Recommendation Report for Planning Permission for Works or Extension to a Dwelling

REF NO: EP/8/25/HH

LOCATION: 58 North Lane
East Preston
BN16 1HN

PROPOSAL: Demolition of existing garage. Single storey rear and side extensions. Existing flat roof replaced with pitched/flat roof.

Drawing P02 January 2025 Scale 1:100 / 1:500 @ A3
Planning Drawing - Proposed Roof Plan, Block Plan & Elevations

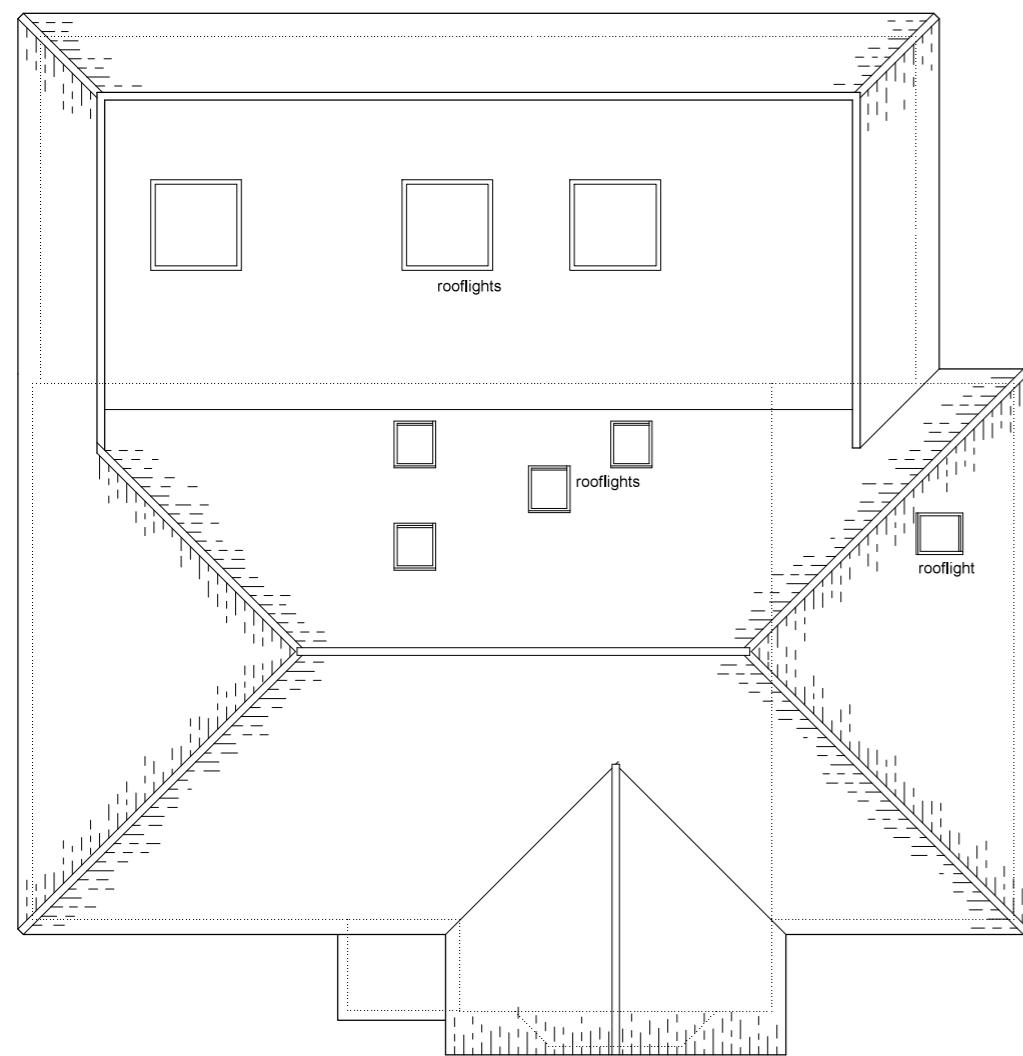
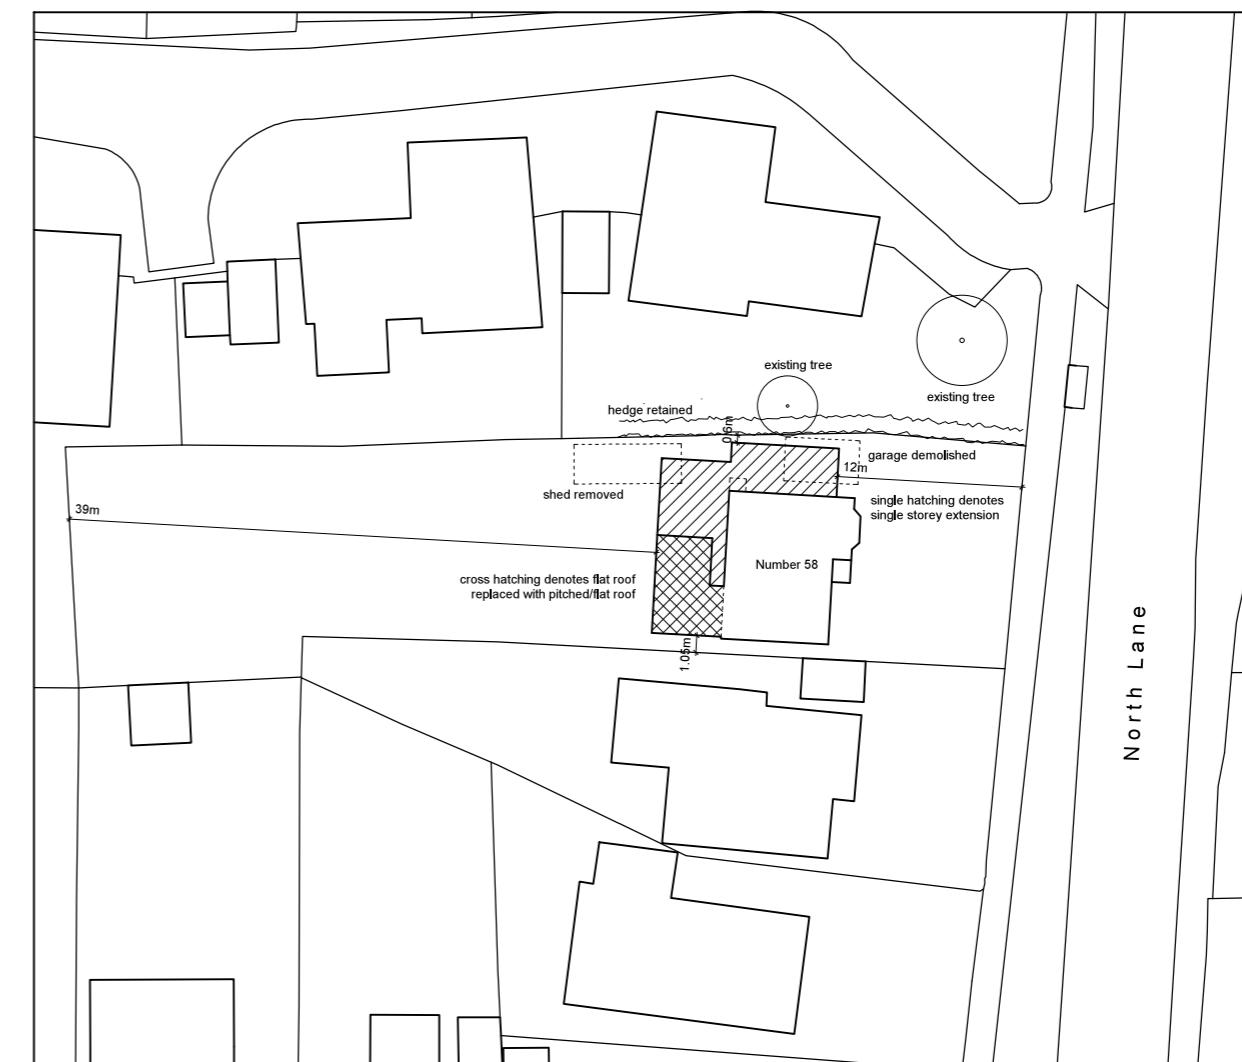
According to the Arun Design Guide (ADG), side extensions should respond to building design in terms of roof pitch and use complementary and integrated materials and elevational design. The extension would integrate well with the existing dwelling in terms of roof form and materiality. The materials would match the existing and are acceptable.

The proposed single storey rear extension would be set in from the northern side boundary, and it would not extend beyond the existing rear elevation of the neighbour to the south. As such, the proposed rear extension would not result in overbearing or overshadowing impacts to neighbouring properties.

Drawing P01 January 2025 Scale 1:100 / 1:1250 @ A3
Planning Drawing - Proposed Floor Plan, Location Plan & Elevations

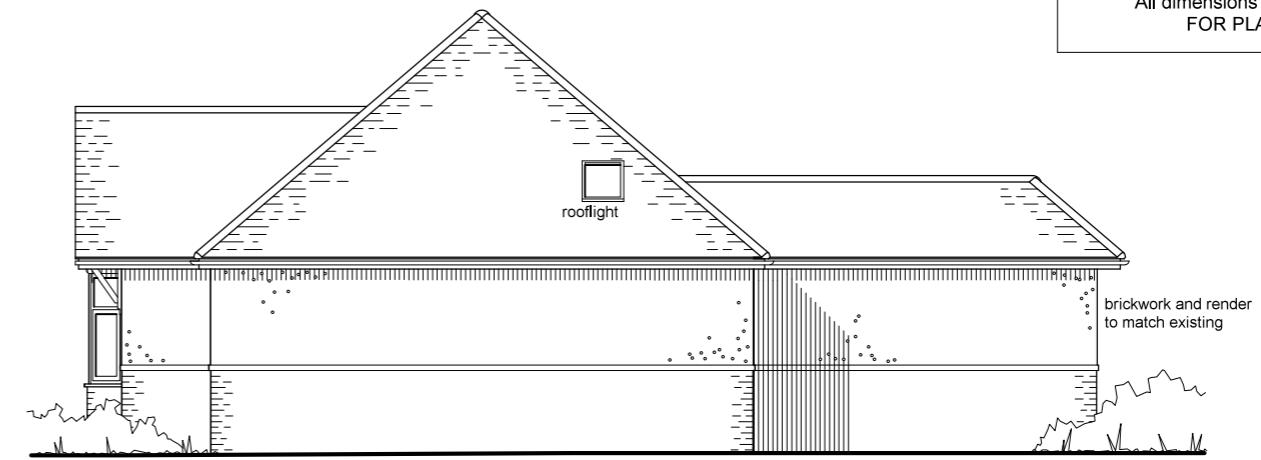
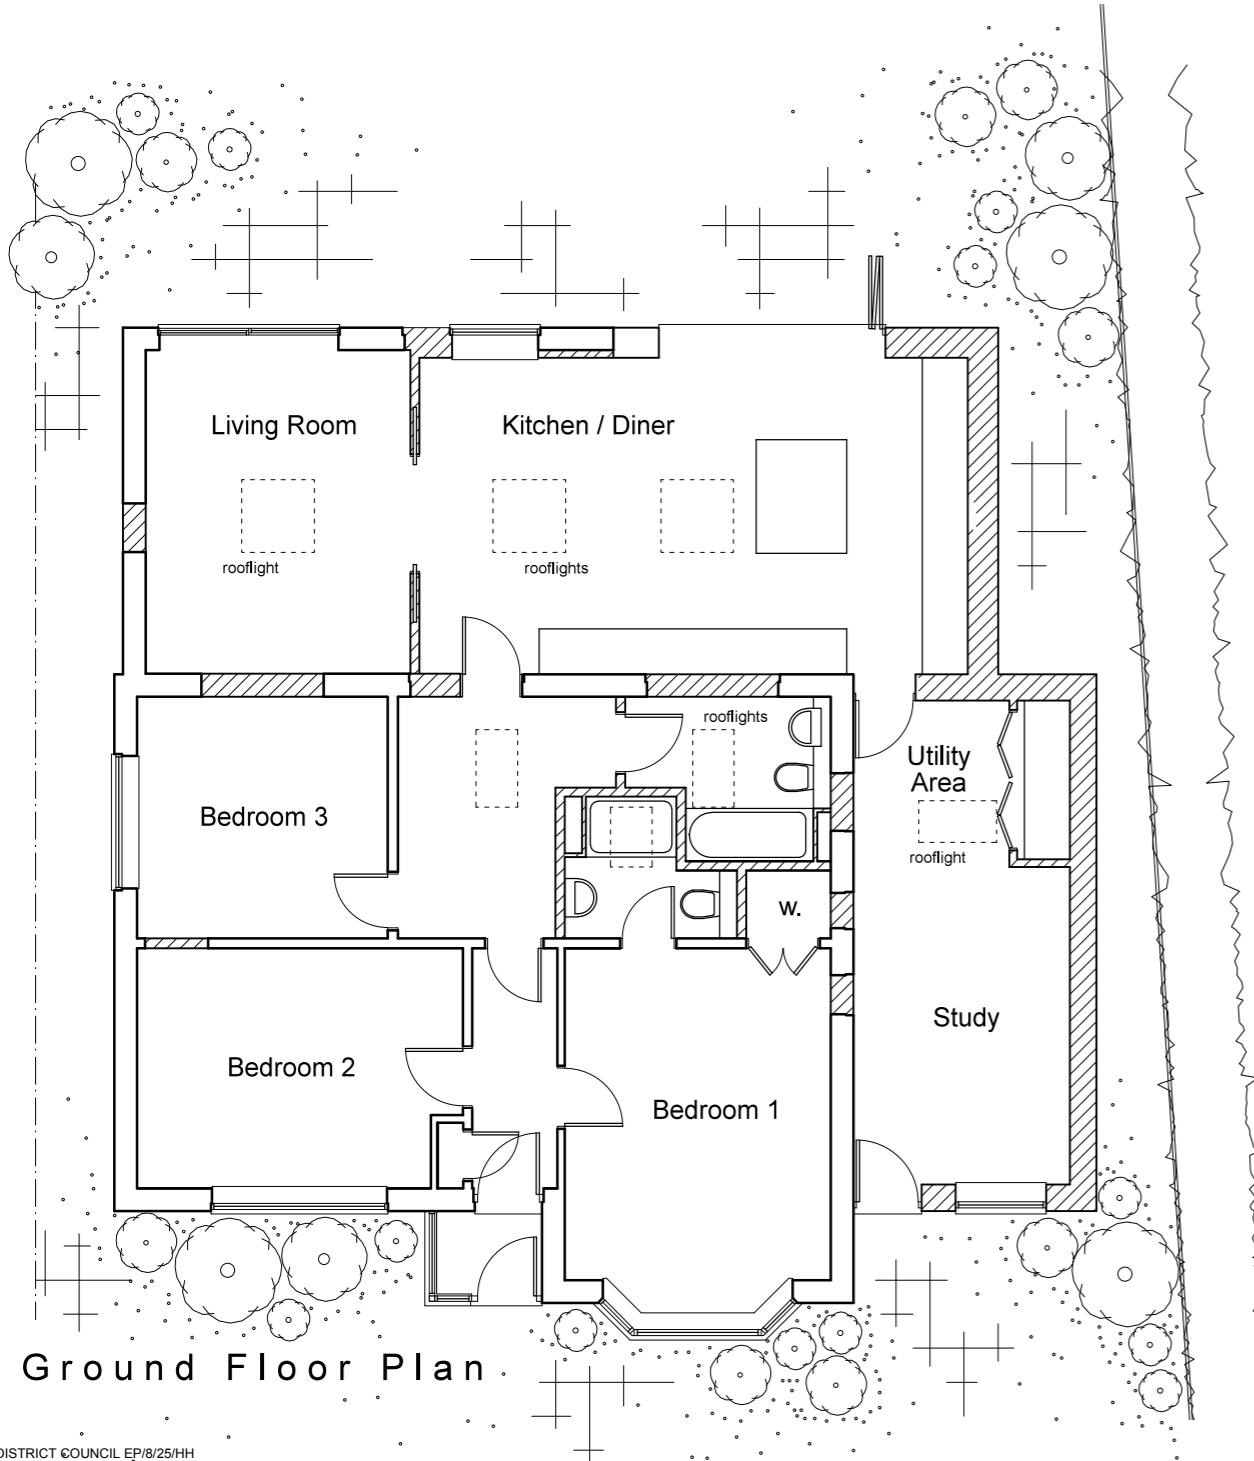
The single storey side extension is proposed to the eastern flank of the host dwelling. The side extension would be set back from the front elevation by 1.5m and would adjoin the rear extension forming a wraparound extension. The extension would have a width of 3.2m and a depth of 7.1m. The extension would have a pitched roof form with a maximum height of 5.8m that would adjoin the roof of the main dwelling and an eaves height of 2.6m. Fenestration is proposed within the front and rear elevations of the extension. The extension would be constructed following the removal of the existing garage. This extension is acceptable as the extension would replace existing built form to the eastern side of the host dwelling and given its design and height, it would not appear prominent or incongruous, in accordance with policy D DM4 of the Arun Local Plan.

The proposed single storey rear extension would include the removal of the existing rear projection. The rear extension element would adjoin the side extension to form a wraparound extension, with a depth of 4.6m. The extension would extend along the entire width of the host dwelling and partly along width of the side extension. The extension would have a crown roof form with a maximum height of 3.7m and eaves height matching that of the existing dwelling. Fenestration is proposed within the rear (west) elevation of the extension.

The proposal would exceed the guidance set out at Part M of the Arun Design Guide (ADG) which states that in the case of detached houses, single storey rear extensions should not extend more than 3.3m from the rear elevation of the original dwelling. Whilst the rear extension would exceed the guidance depth, it is noted that the extension would not extend beyond the existing rear elevations of neighbouring properties, and given the design and siting of the proposed extension, the extension would not result in any harm to the character or appearance of the host dwelling or street scene.

The proposed single storey side extension would extend towards the northern boundary of the application site, set in a minimum of 0.6m. It is noted that the side extension would replace an existing garage which is currently situated closer to this boundary than the proposed side extension. The proposed side extension would have a hipped roof form and an eaves height of 2.6m. As such, given the spacing between the side extension and the neighbour to the north, and the eaves height of the

In terms of overlooking, fenestration is proposed within the front elevation of the side extension, with an outlook over the application site frontage. Fenestration is proposed within the rear elevation of the rear extension, which would have an outlook over the rear amenity space serving the host dwelling. As such, the proposed development would not result in any overlooking.
